SANDSTONE PRECINCT

DESIGN REVIEW PANEL - ADVICE 13

13 July 2020

Date Printed: 20/7/20

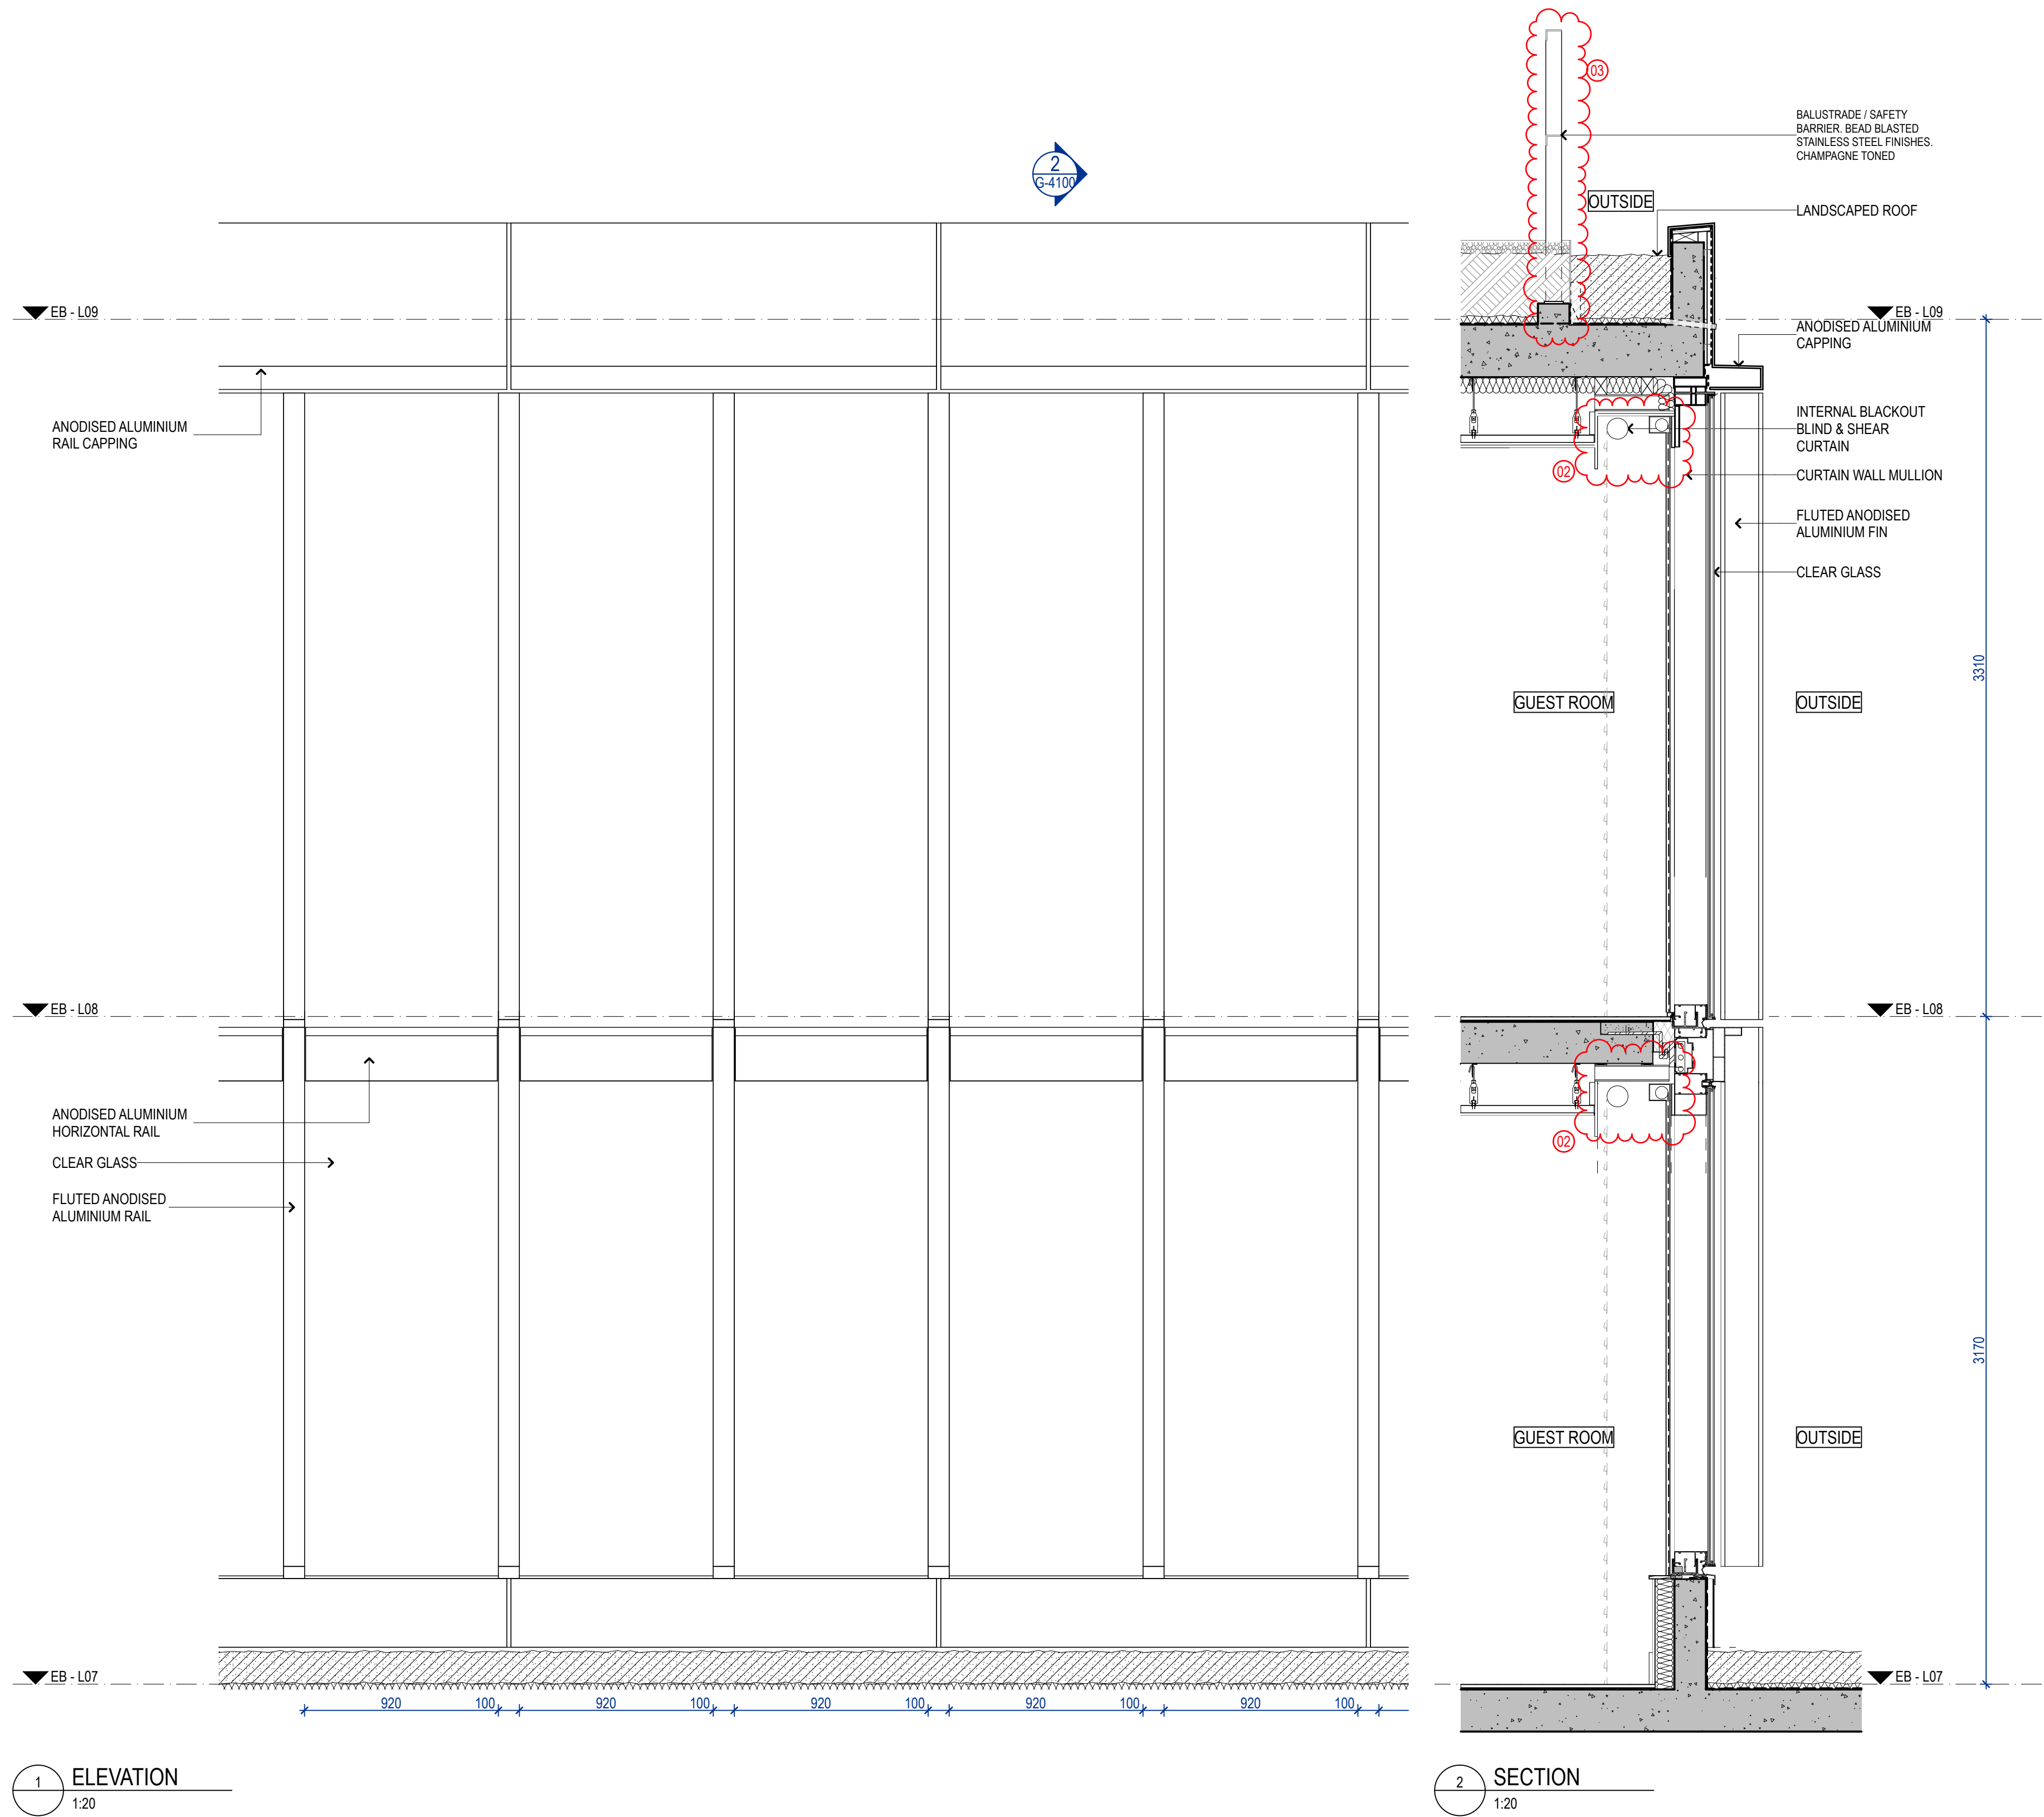
- . *Curved glass radius increase to 1500mm (External and Internal) & Mullion adjustment around curved glass corners.*
- . *External North elevation changes to cladding on level 9*
- . *External East elevation hidden door relocation on level 9*

The Panel supports these changes.
